Application No: M/68/20/PL
Site Address: Poultry Farm 87 Yapton Road Middleton-On-Sea PO22 6DY
Description of works: Demolition of the existing structures & redevelopment to provide a new 66-bedroom care home arranged over two storeys together with associated access, car & cycle parking, structural landscaping & amenity space provision (resubmission following M/80/19/PL). This application is in CIL Zone 4 (Zero Rated) as 'other development'.

Thank you for your internet representation made on 30th September 2020 which has been recorded as an objection with the comments as follows:

- Key:**
- Root protection area for tree to be retained
 - Canopy of tree to be retained
 - Tree protection fencing
 - Secondary tree protection fencing
 - Construction exclusion zone
 - Secondary construction exclusion zone
 - No-dig surface

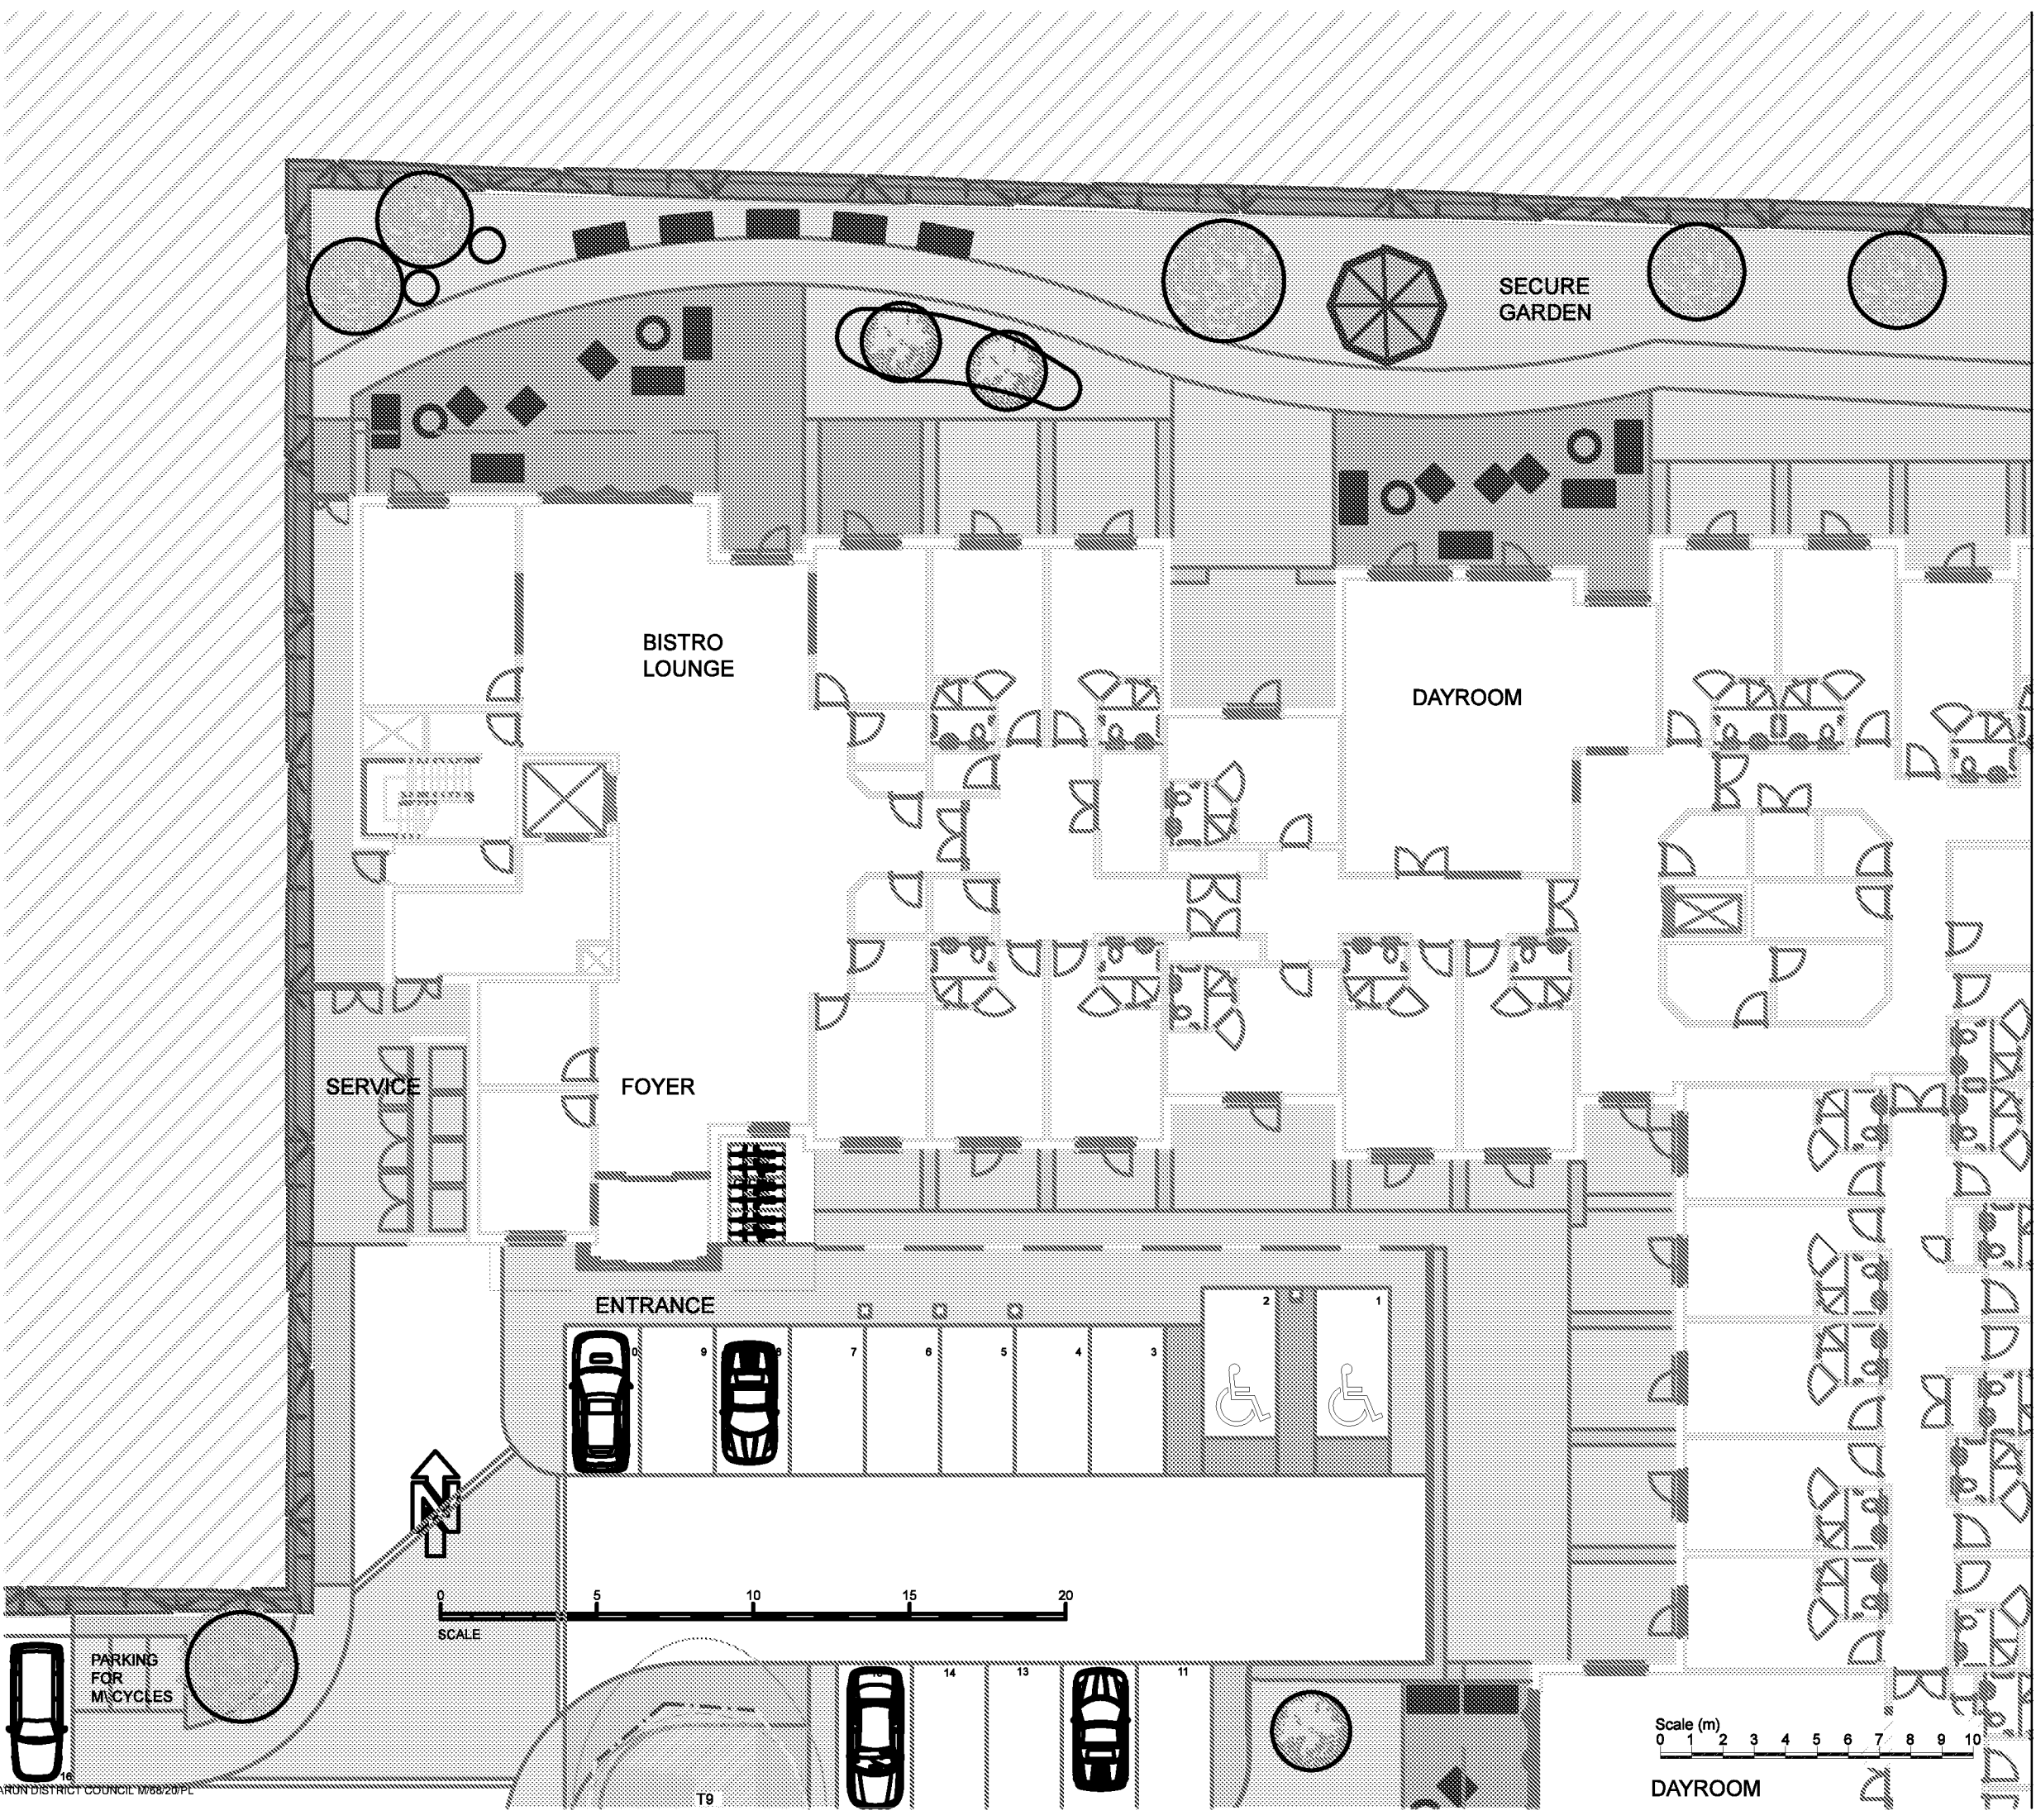
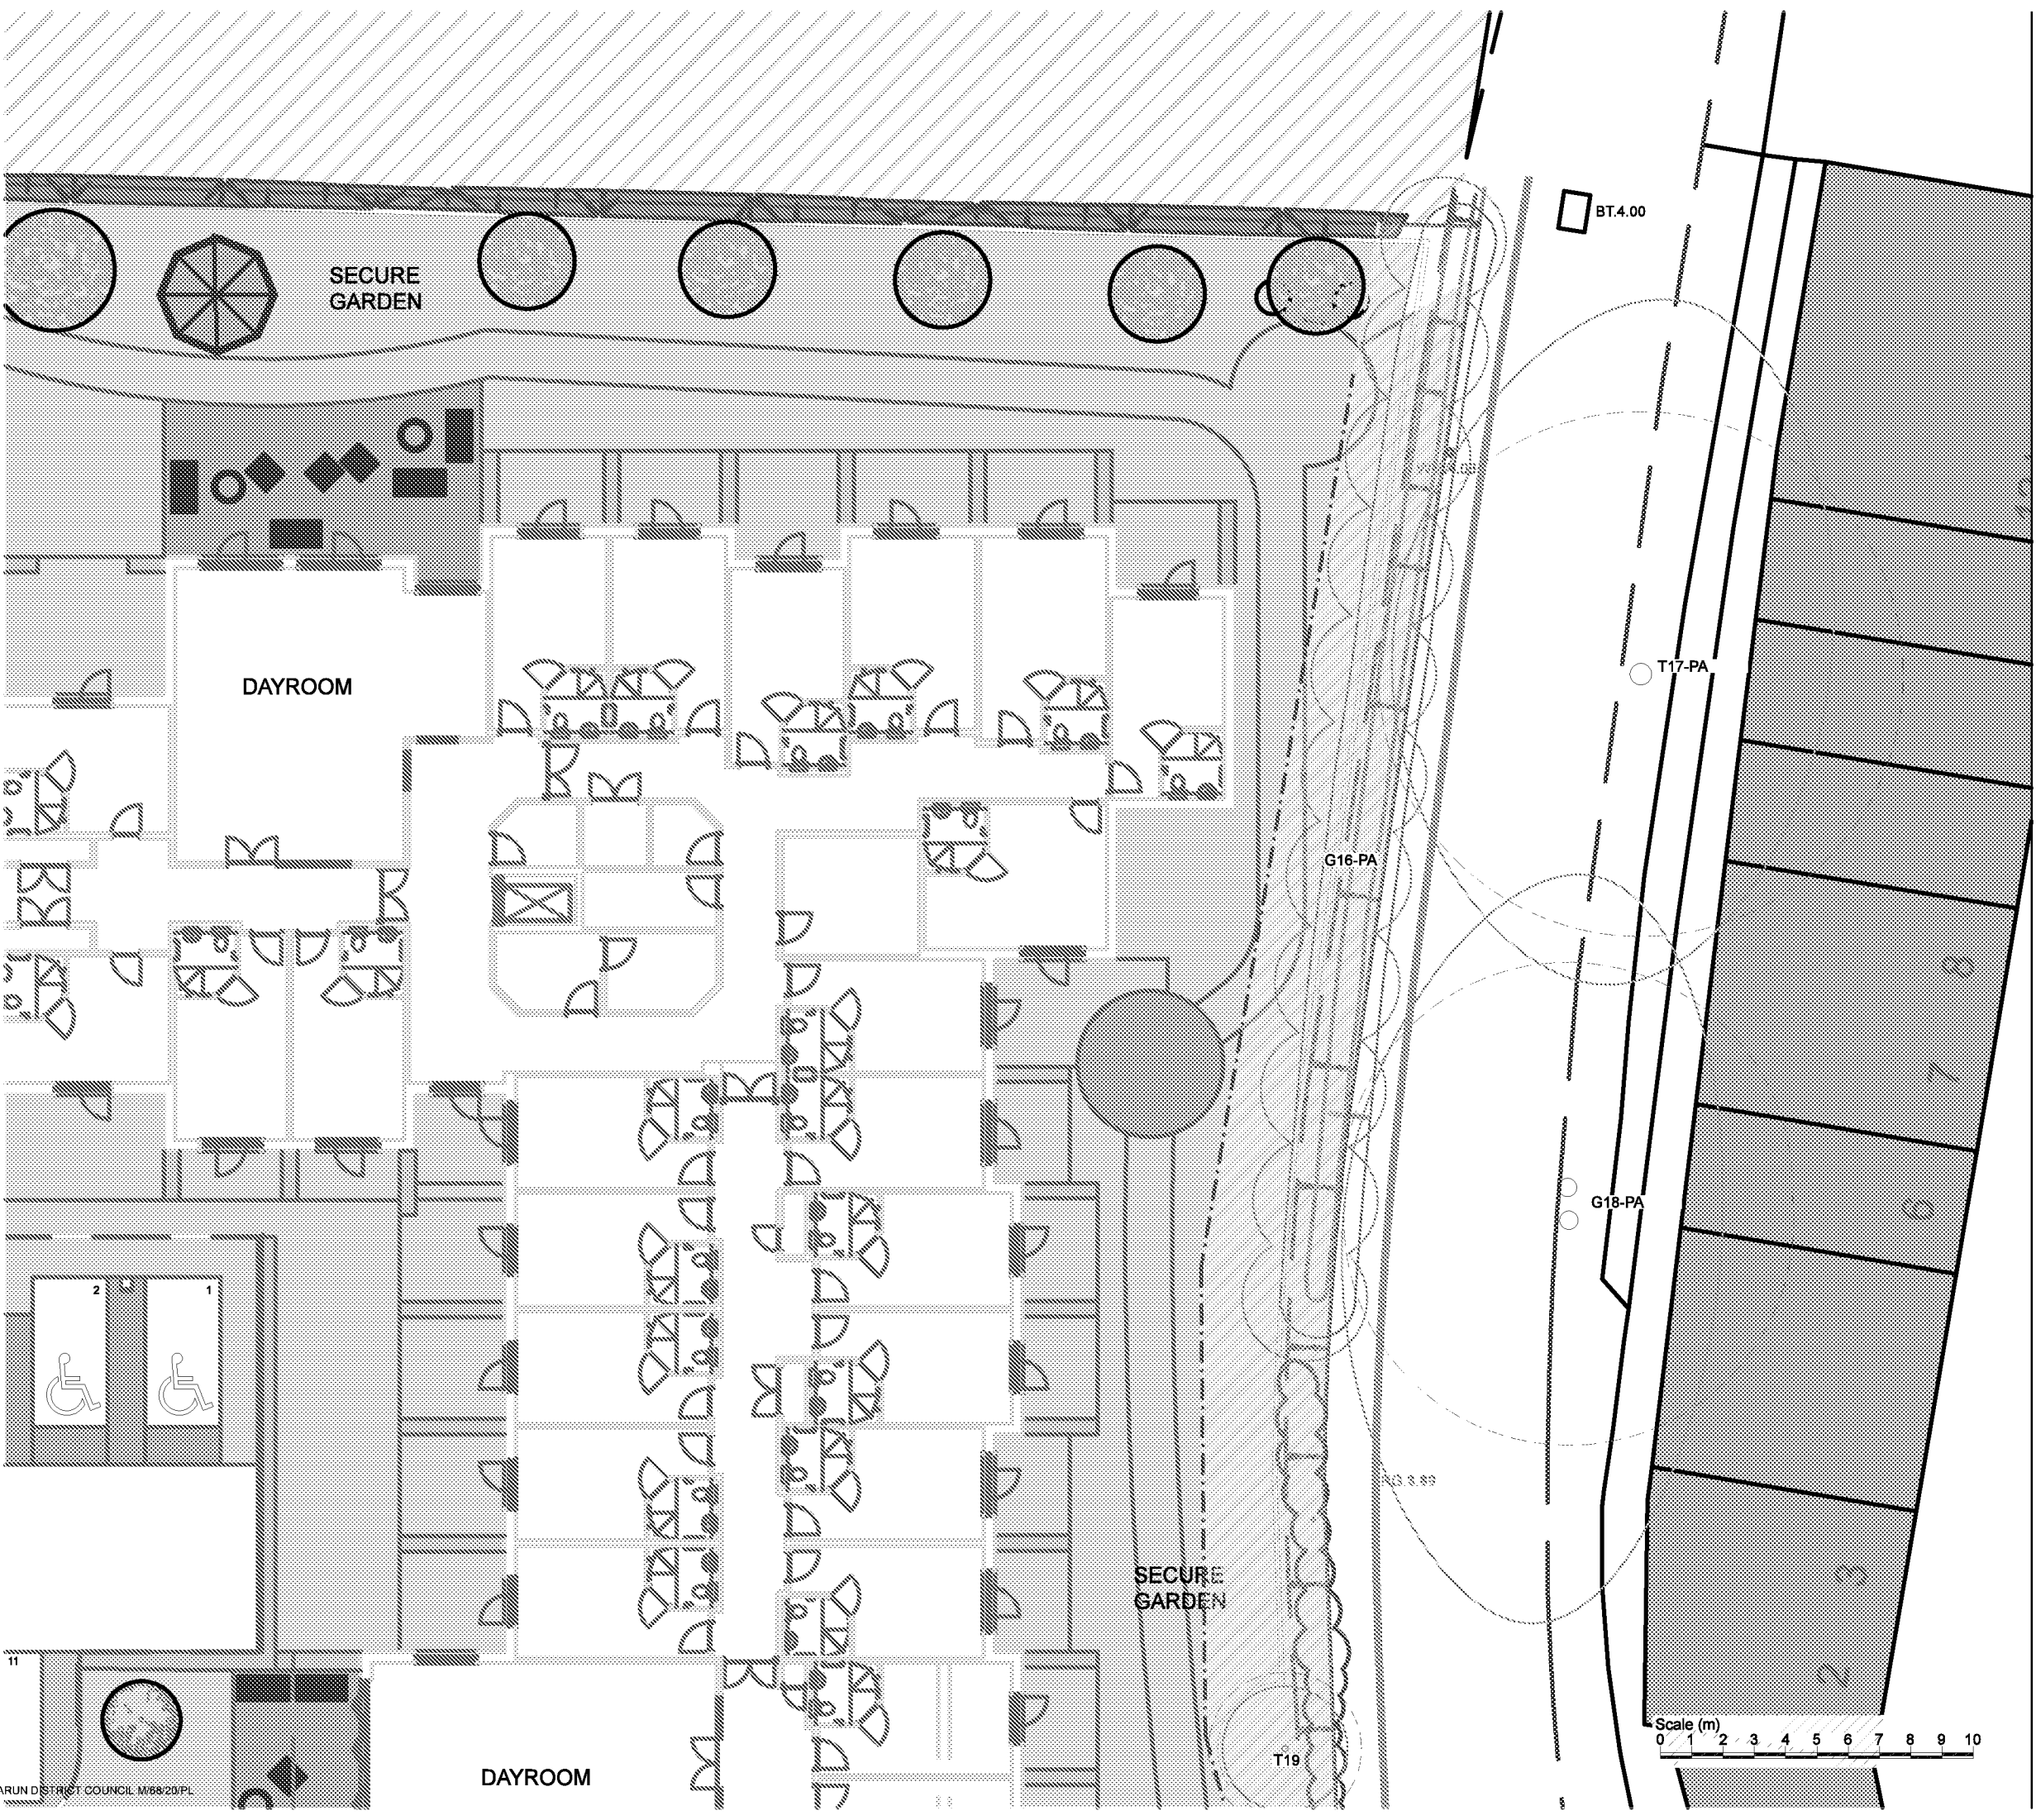
Why have all the protected trees got new numbers?

This is very confusing and we would not want the wrong trees to be chopped down by mistake by anyone would we?
